**CITY OF PORTLAND, MAINE  
Portland Community Health Center Renovations  
Bid #2713**

Receipt of **Addendum No. 2** to the City of Portland's Bid #2713, **Portland Community Health Center Renovations**: is hereby acknowledged.

**Meeting Minutes****Mandatory Pre-Bid Meeting**

**E 201**

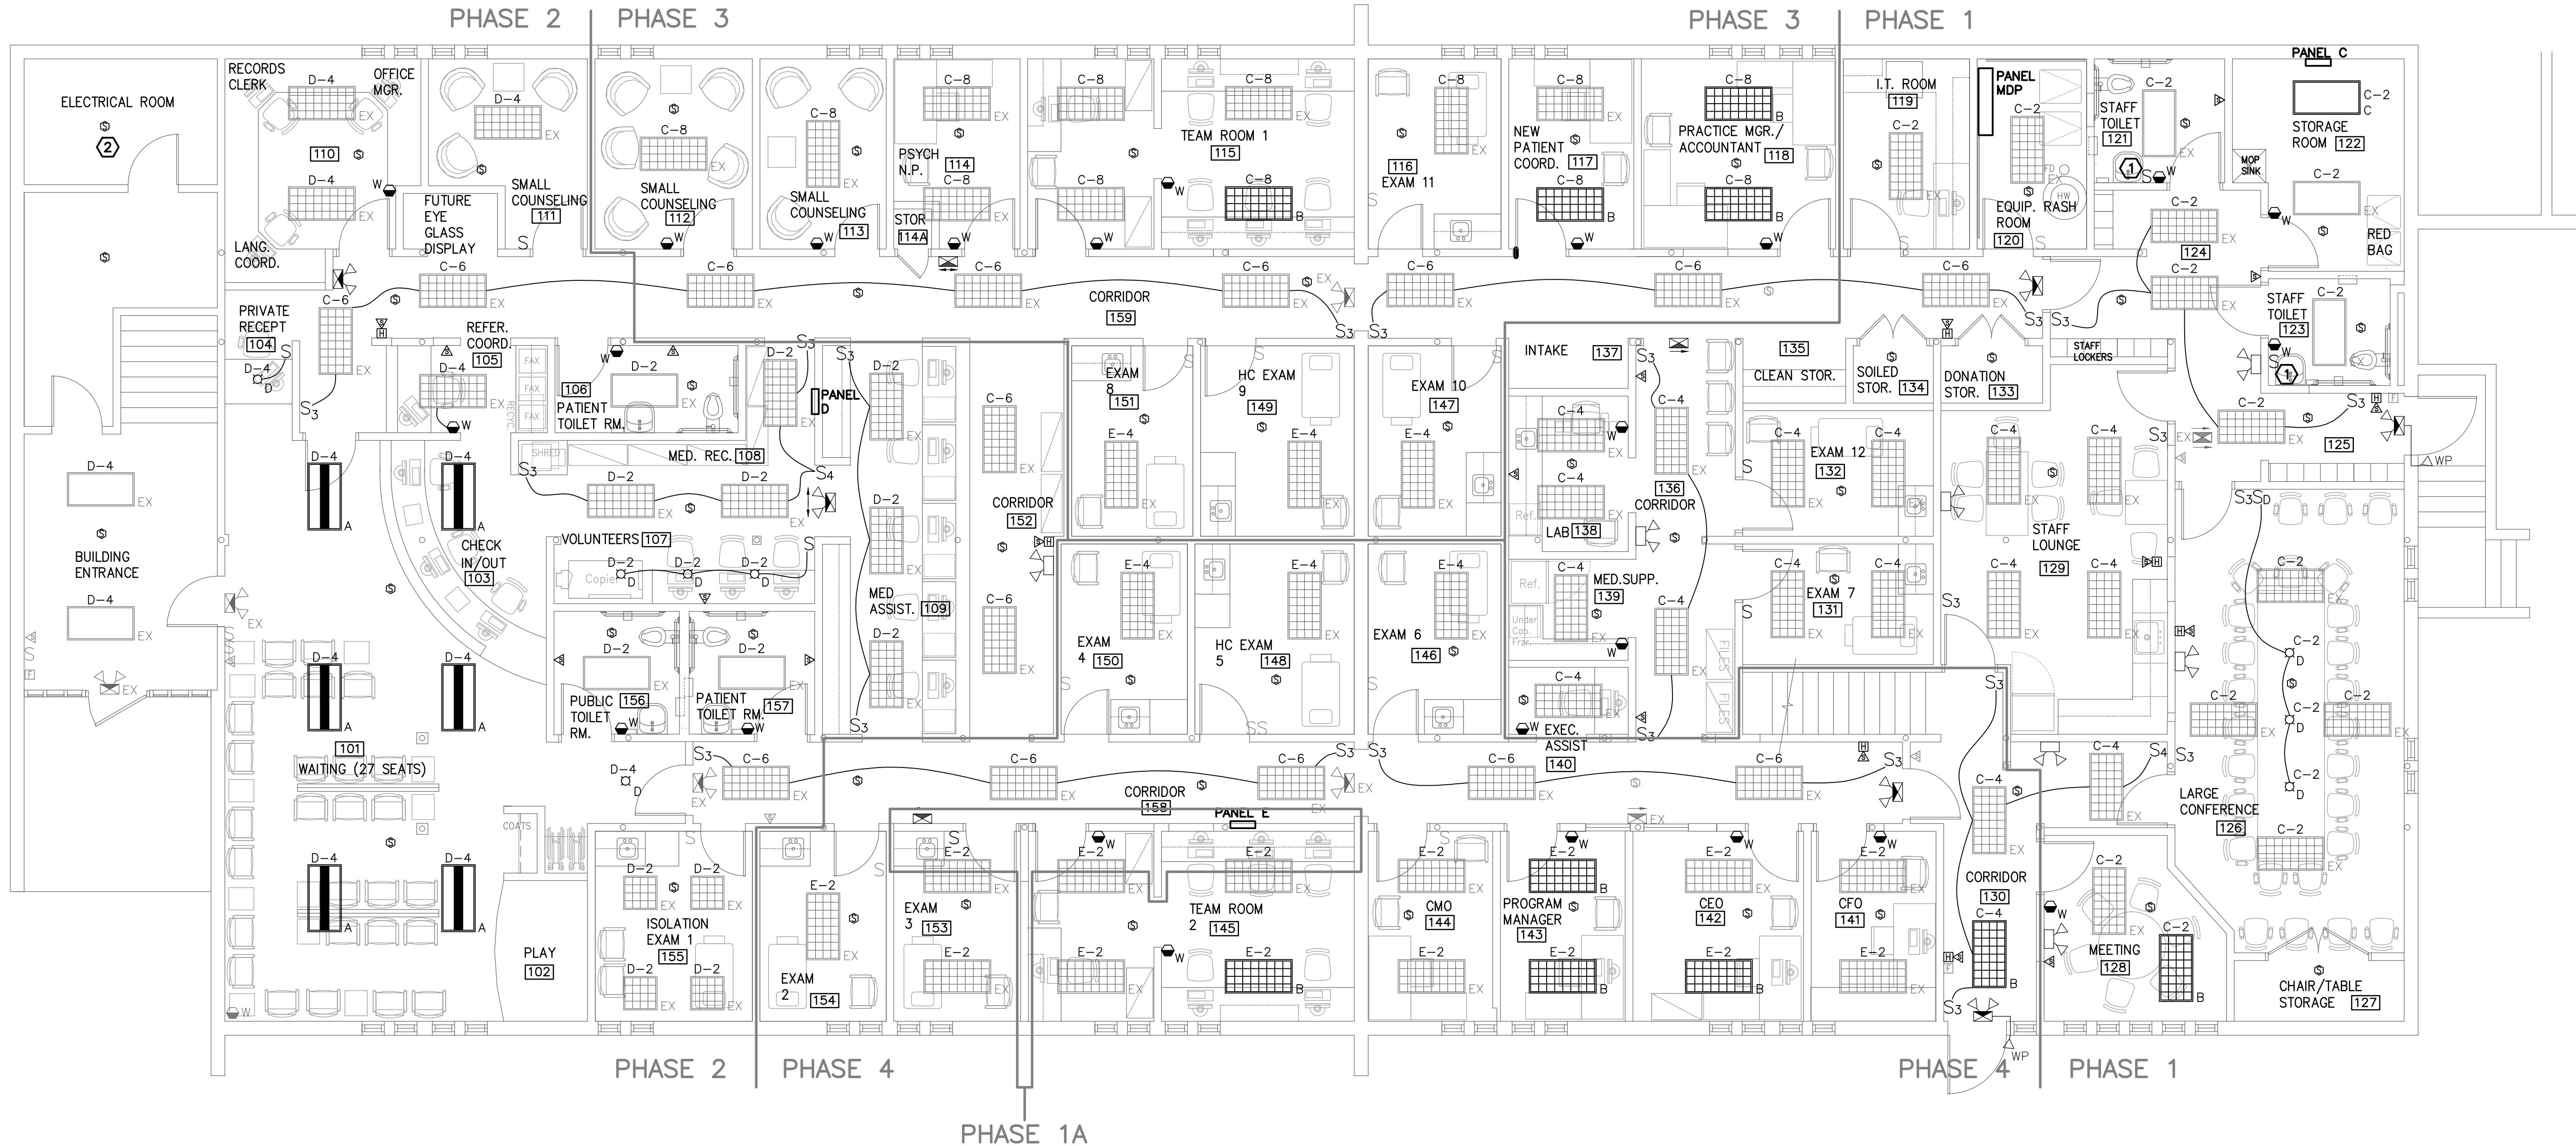
11. *Will there be any strobes in the exam rooms?*

12. *Some of the public bathrooms do not seem to have a strobe. Do they need a strobe?*

Strobe units for the exam rooms should have been shown on the original drawing E201. Attached is a revised drawing showing additional strobes and other clarifications identified by the State Fire Marshal in his review of the plans.

Strobe units for the bathrooms should have been shown on the original drawing E201. Attached is a revised drawing showing additional strobes and other clarifications identified by the State Fire Marshal in his review of the plans
